Change surface finish of drive and path
Kingsgate 49 The Drive Aldwick

AW/238/12/

Change surface finish of drive and path

SITE LOCATION PLAN
AREA 2 HA
SCALE 1:1250

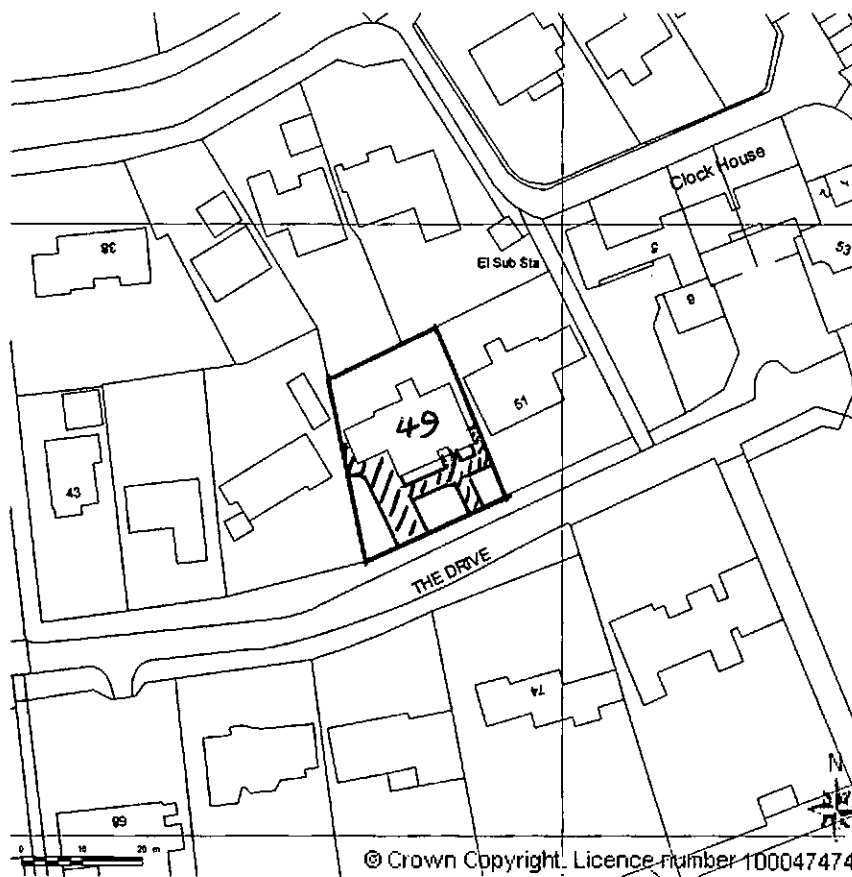
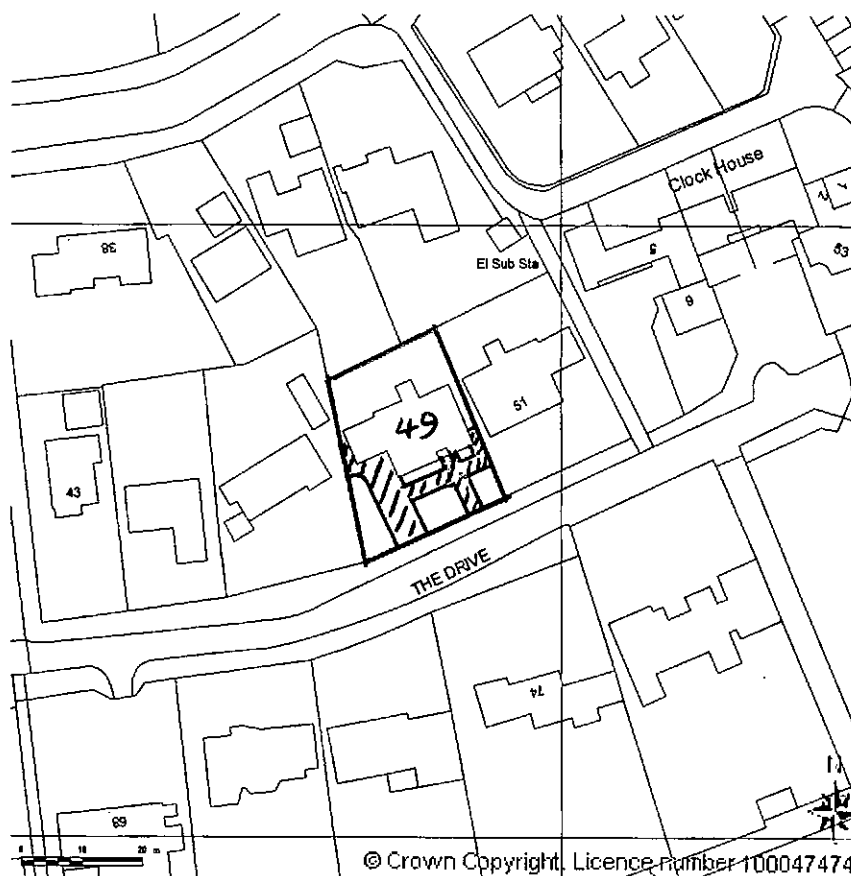
The proposal is for a replacement surface material to an area which provides both driveway and pedestrian access. I note that the area to be covered is exactly the same as that covered by the existing material. The area is fairly substantial and any proposal will potentially have an impact on the locality.

Is it possible to confirm the material to be used; is it slate or a material dressed to look as though it is slate?

However, as the proposal currently stands, it does not enhance the conservation area, but it can't really be said to detract from it either.
